FORESTS NSW

17 February 2013

RE: Woolgoolga to Ballina Pacific Highway Upgrade SSI-4963

I refer to your recent advice that comment was invited on Environmental Impact Statement prepared for the Woolgoolga to Ballina Pacific Highway Upgrade Project.

Figure 17-1: Existing agricultural land in the project study area

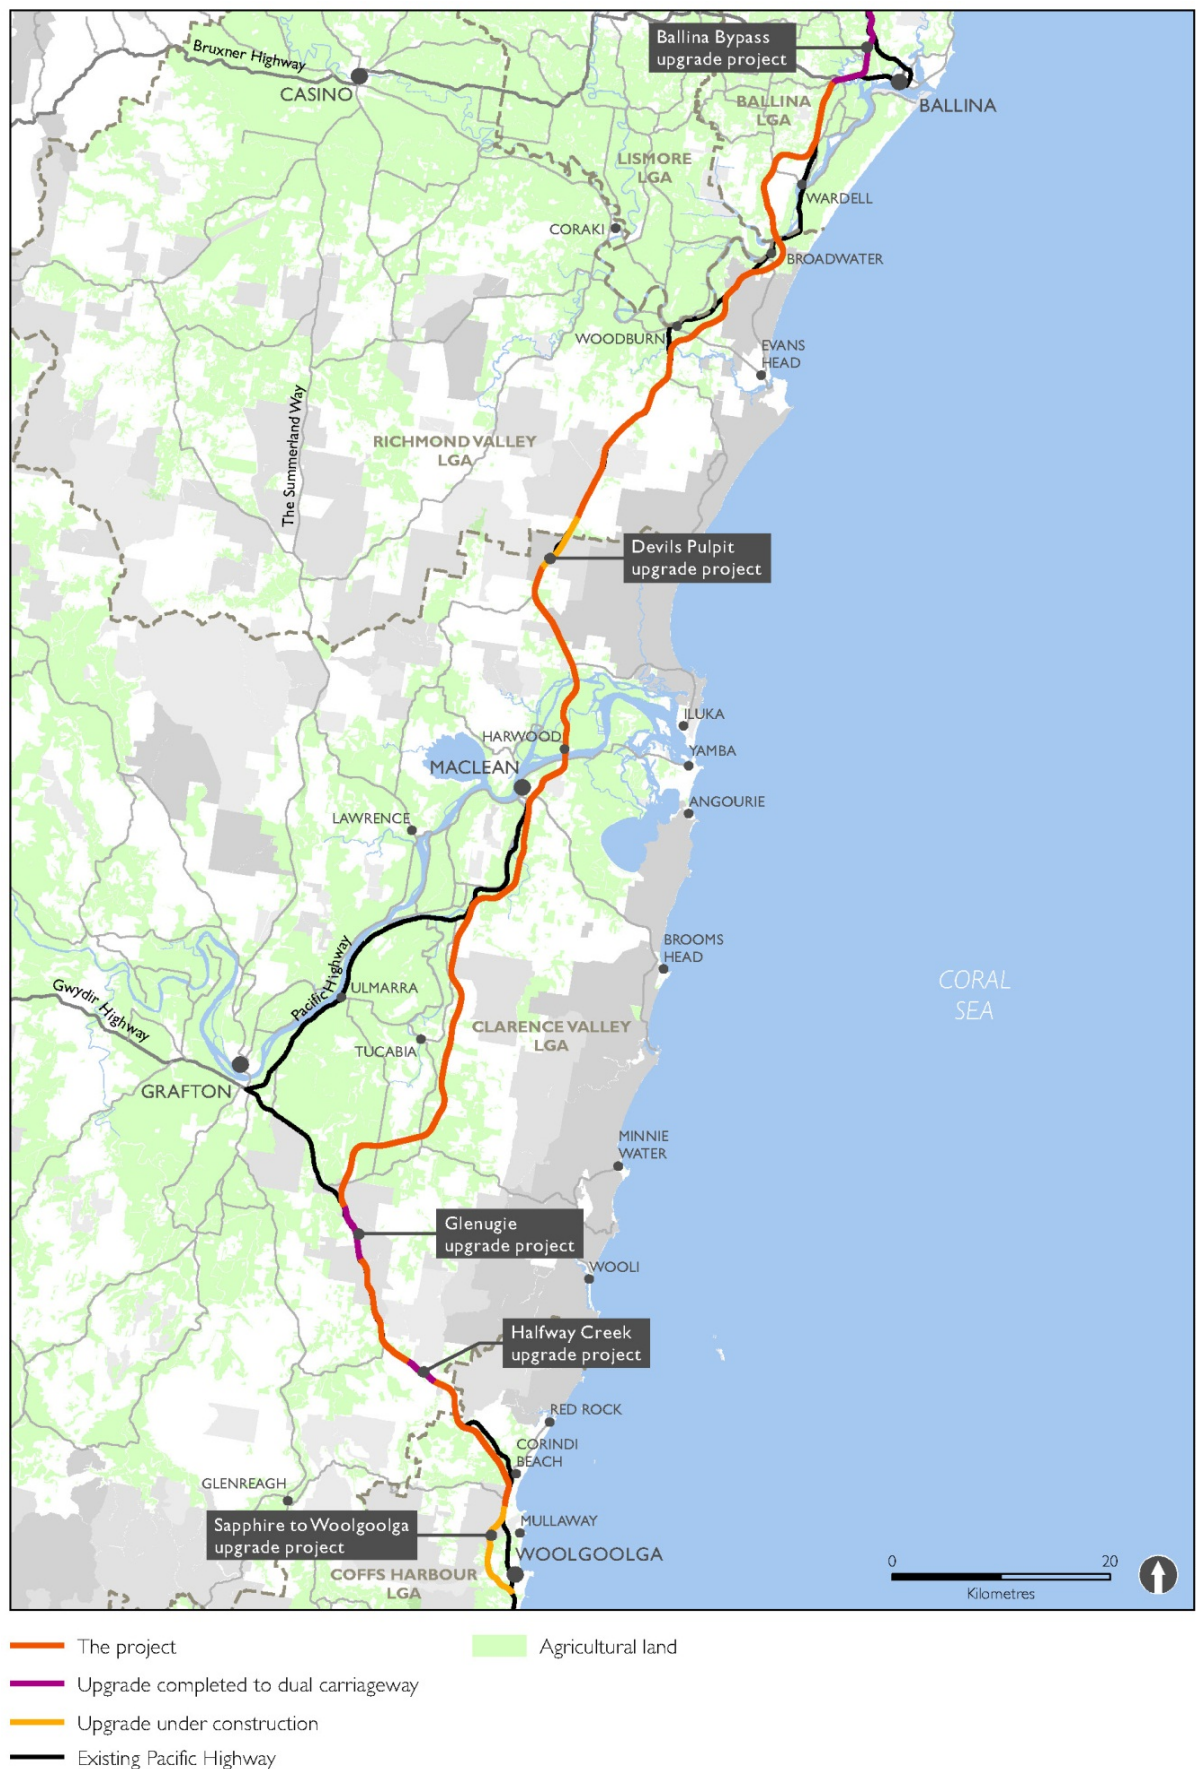
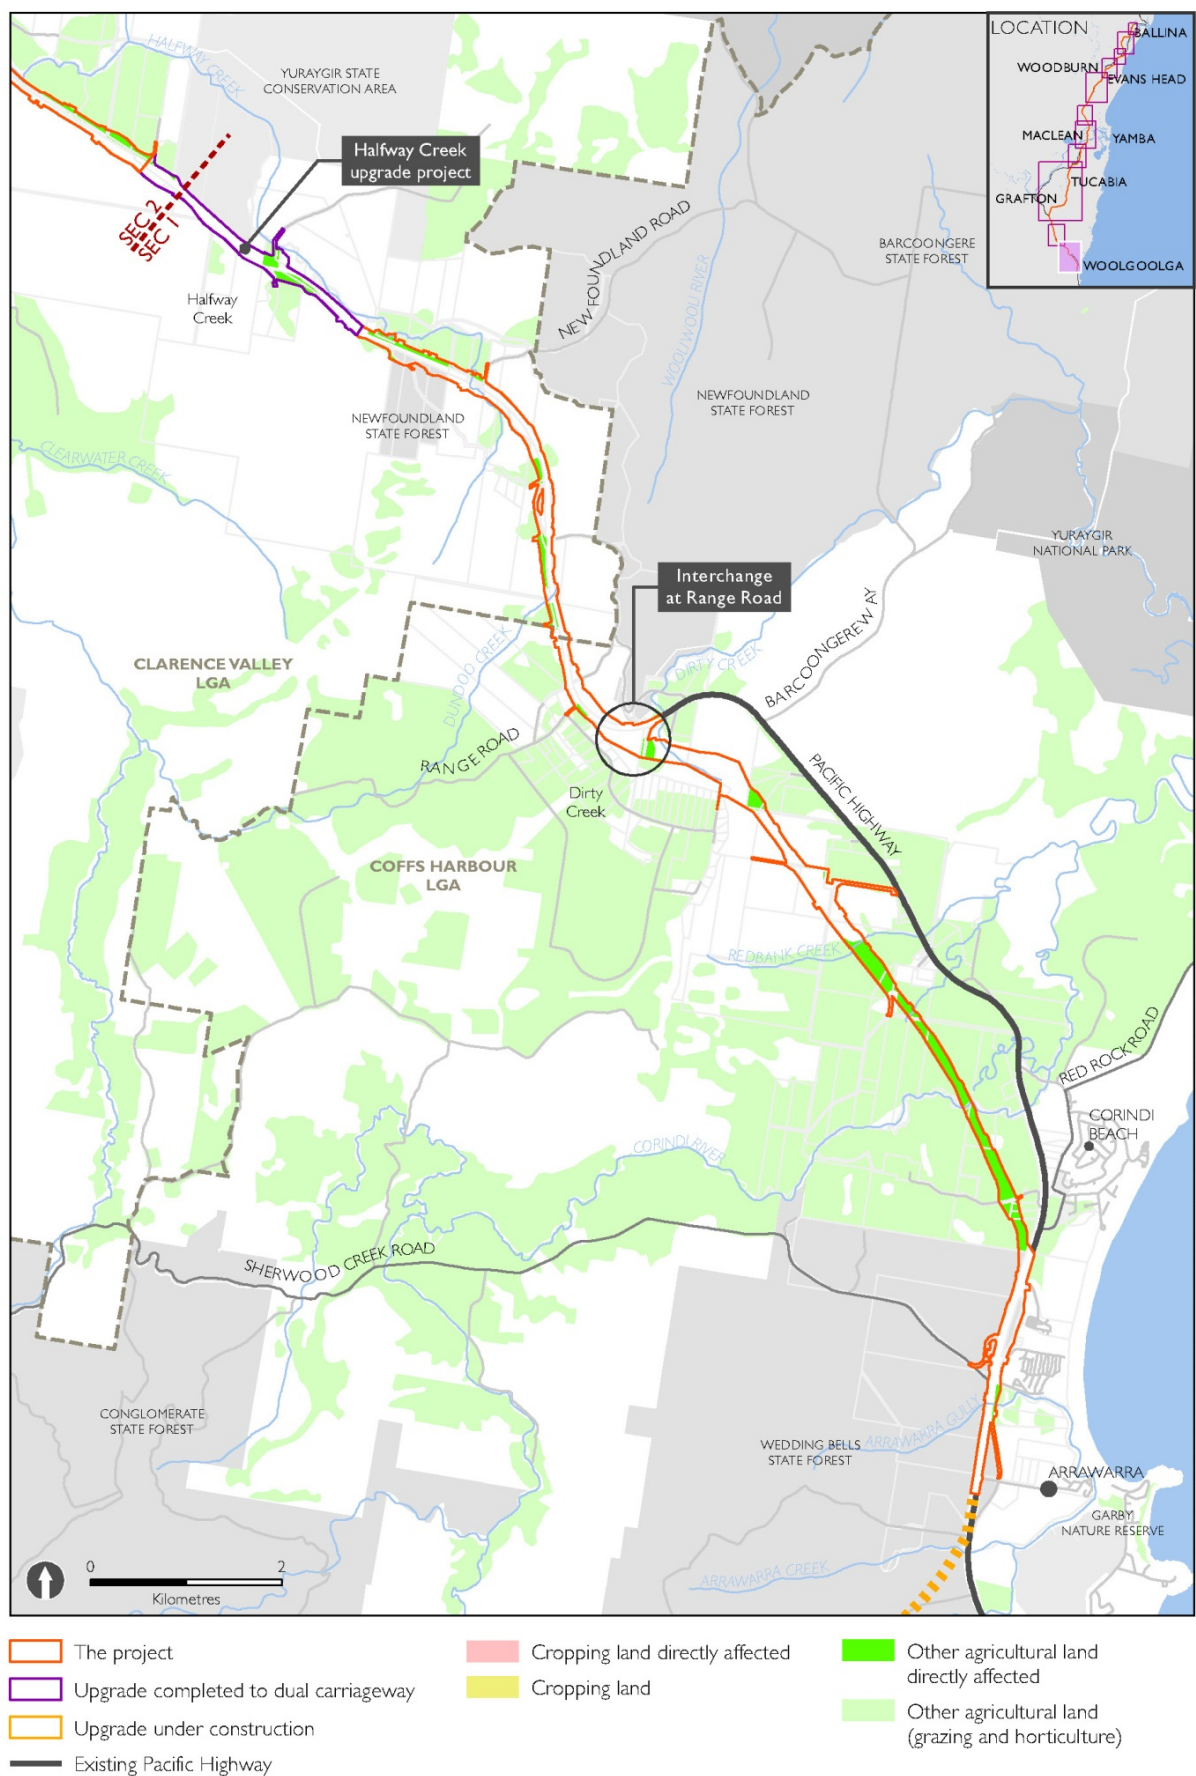
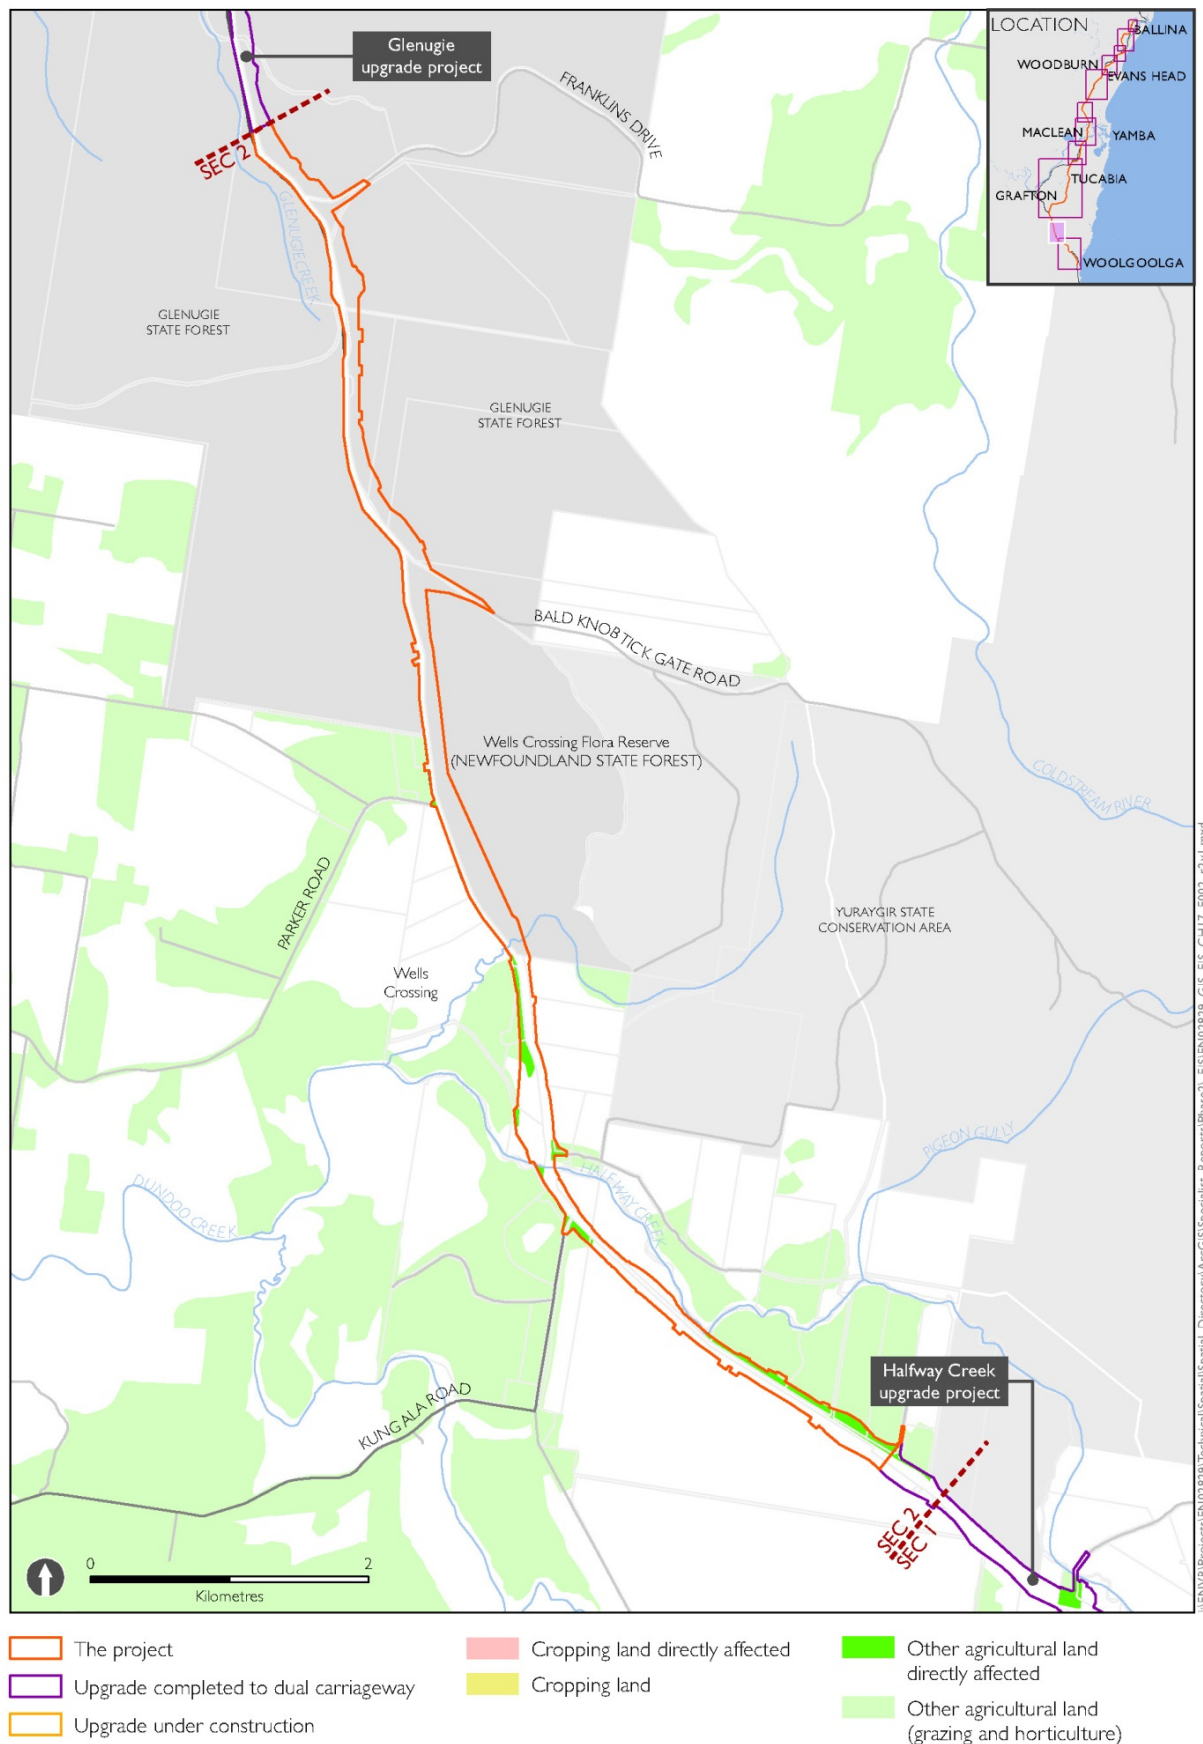
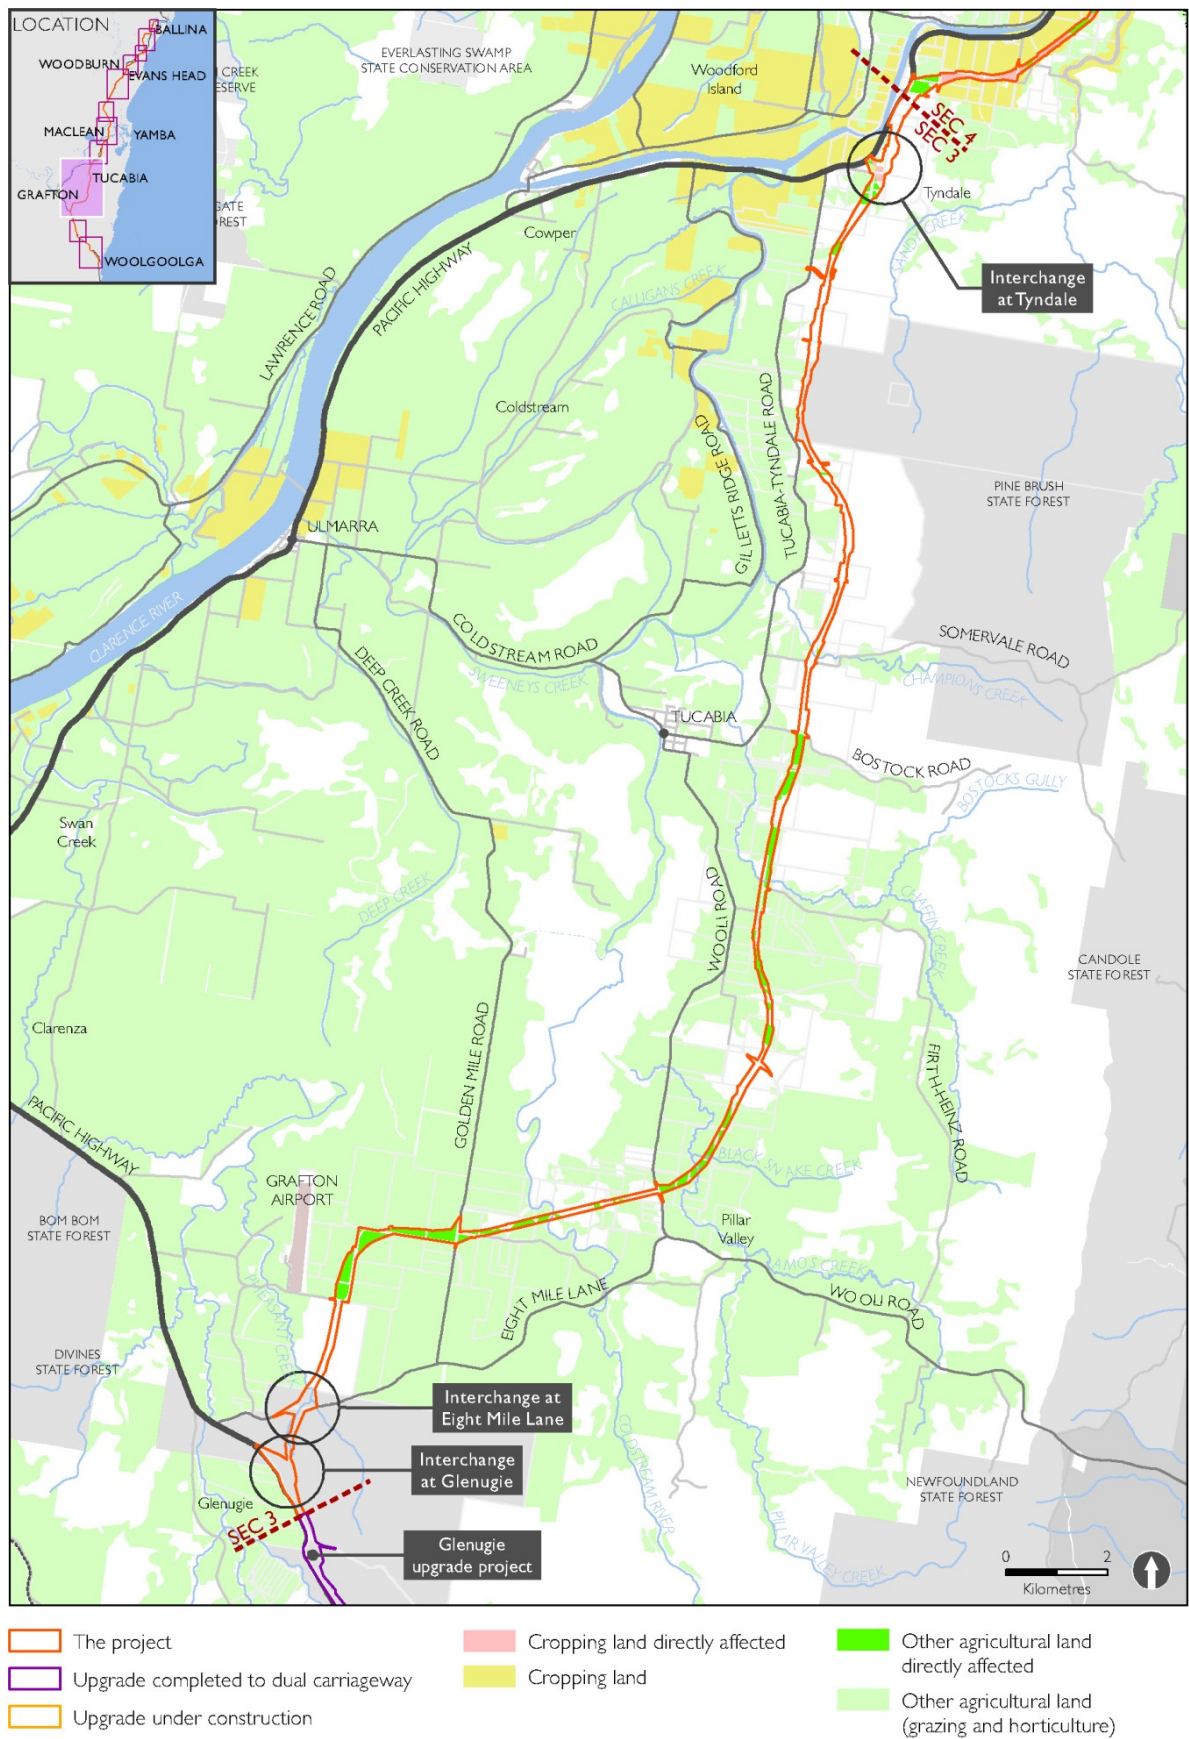
Tables 4.4 and 4.5 of the Social and Economic Working Paper and Table 17-2 in Section 17.3.4 (Agribusiness) of the Chapter provides an estimate of area of "hardwood production" within the Local Government areas affected by the project as well as an estimate of the area affected directly by the project. The areas cited may be limited to areas of hardwood plantation only and the impact on the area of native forest used for hardwood production has not been considered.
